**Subject:** 22/01599/DISC - Land Approx 1 Mile From J9 East Of M40, Part Of M40 Through Chesterton Parish, Chesterton

Landscape Architect

Cherwell District Council

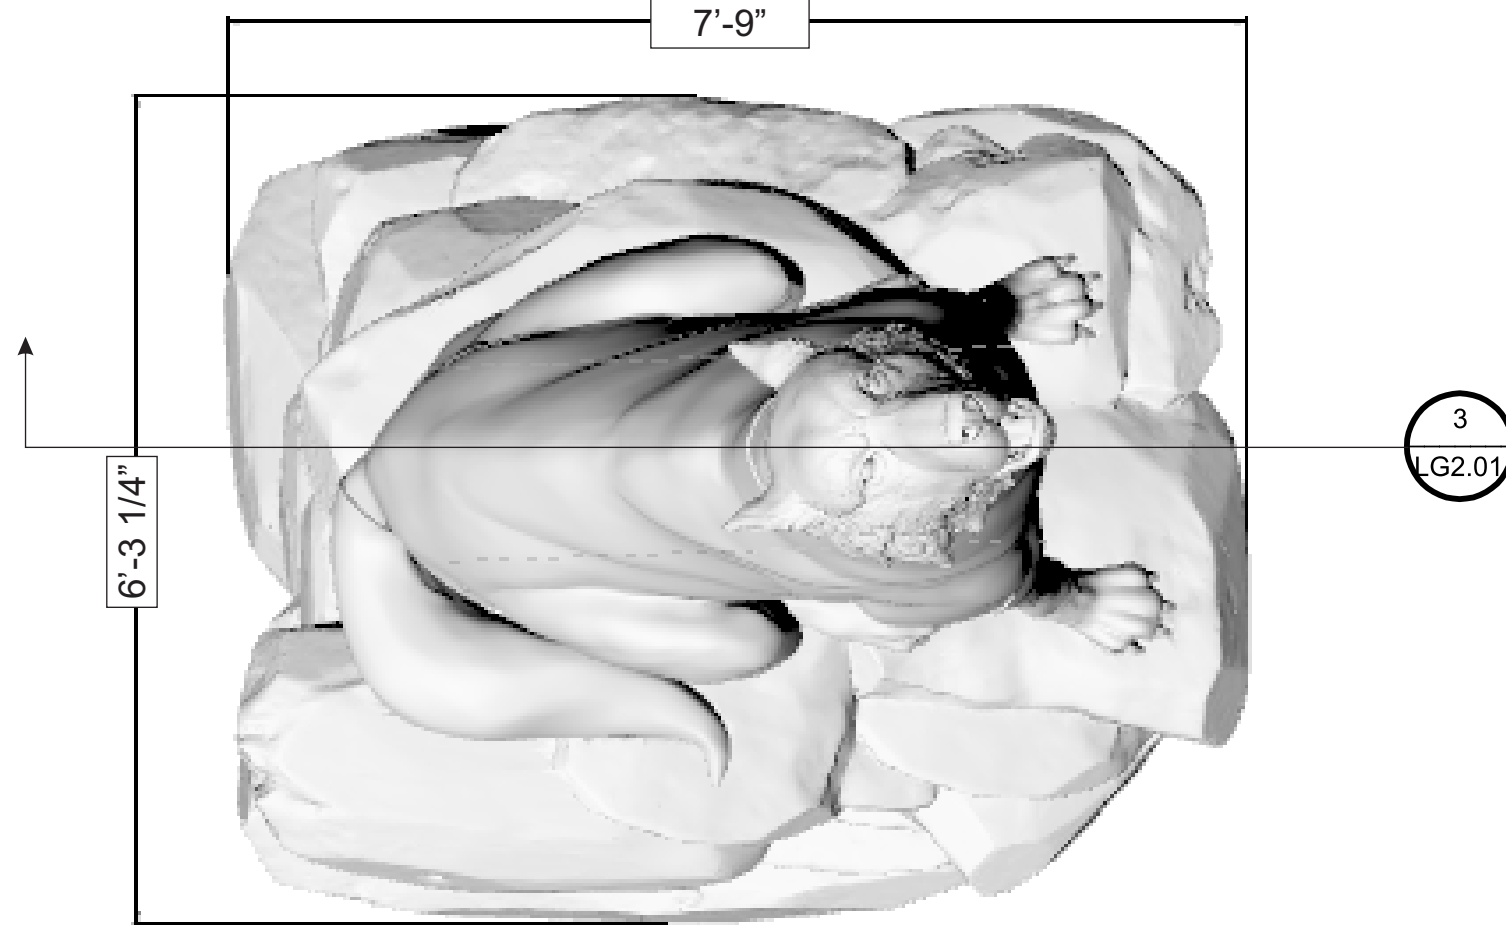
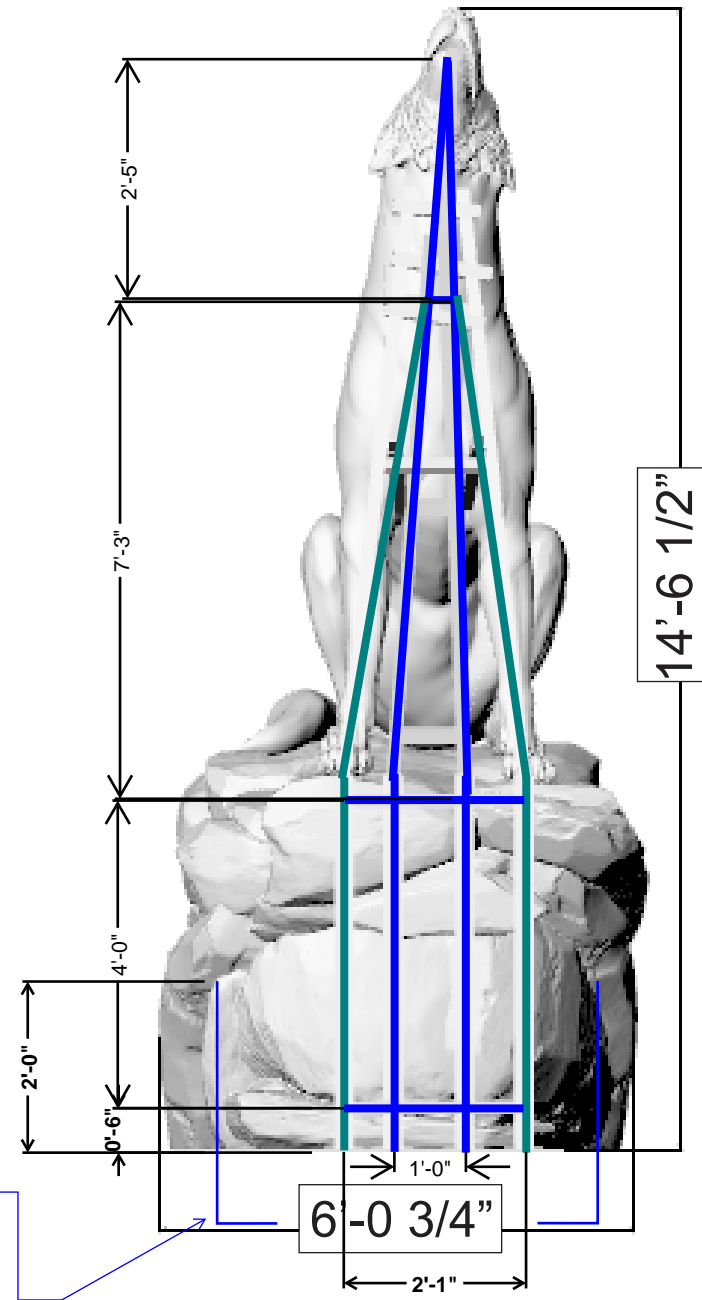
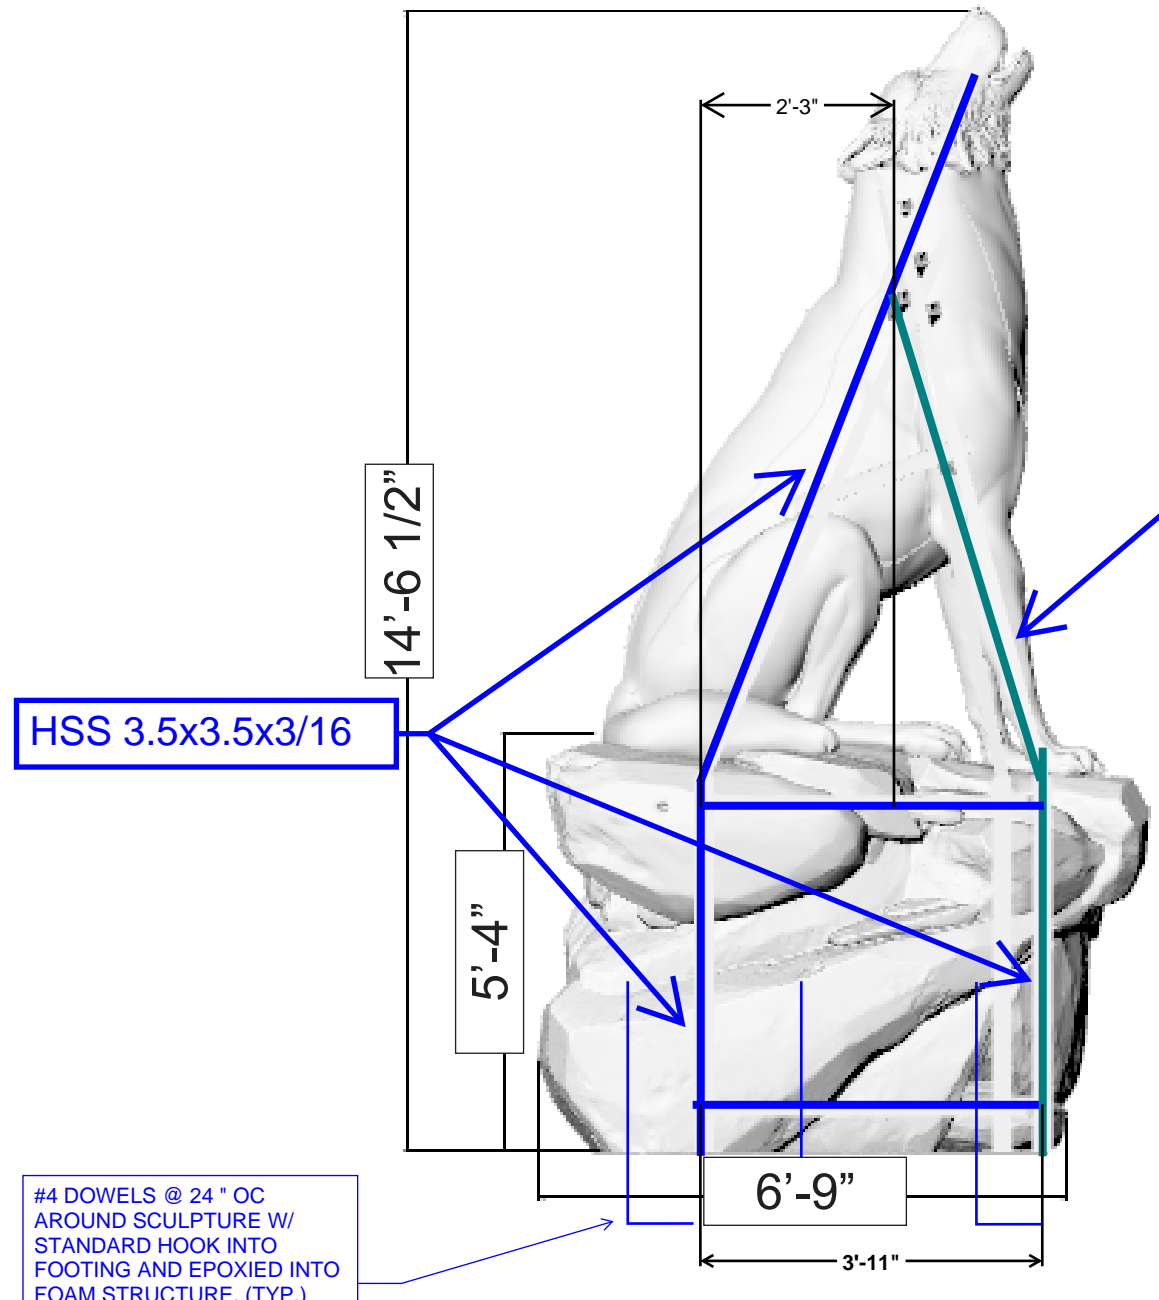
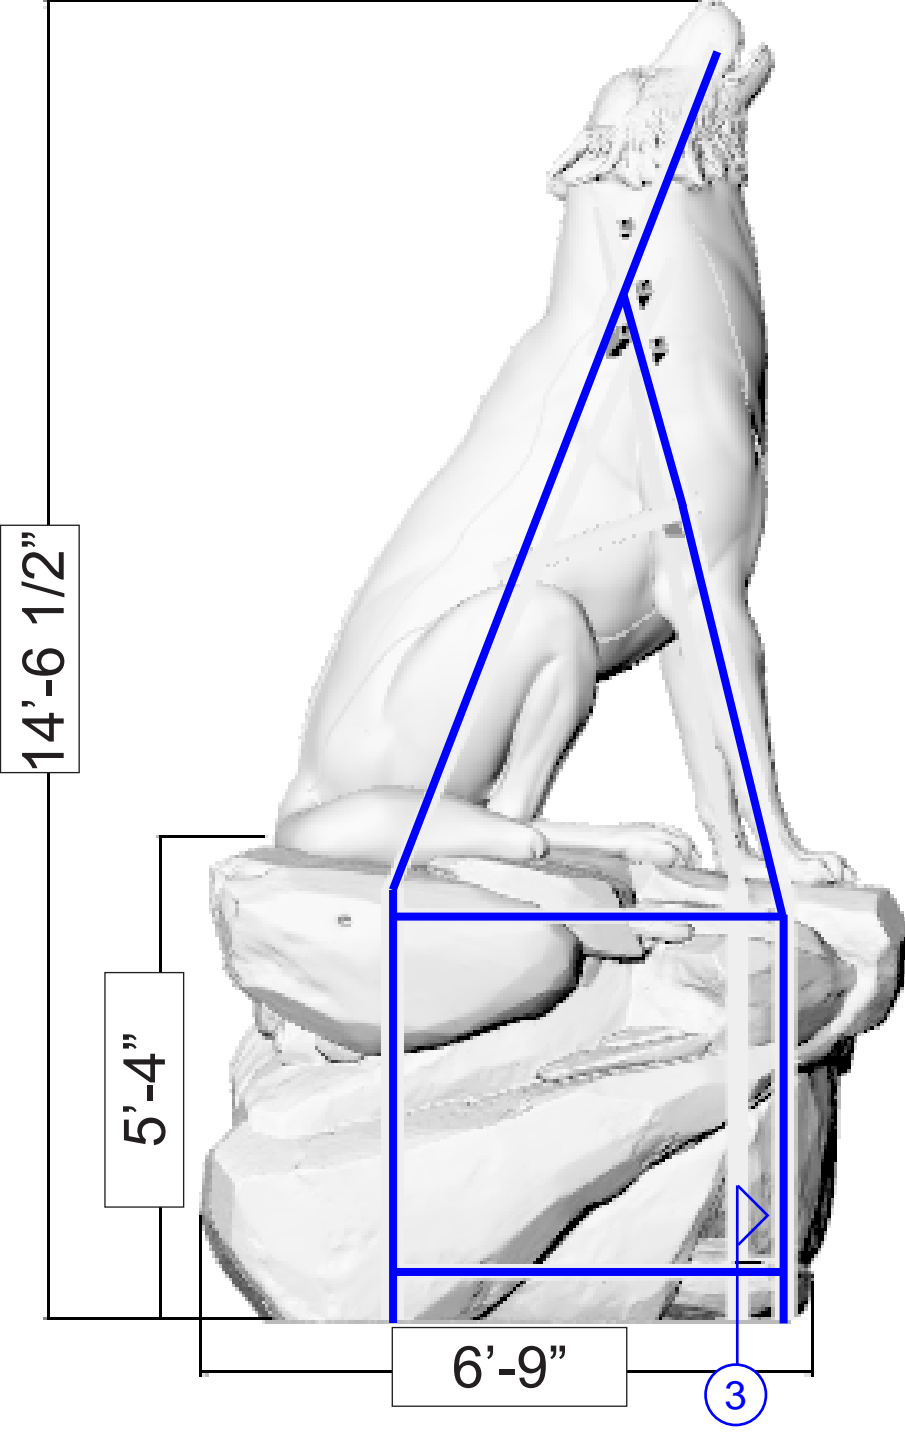
Have considered the proposals and my only comment is the wolf sculpture is not as finely carved as I would of hoped. I would suggest a local artist is employed to design and create an exemplary piece of sculpture.
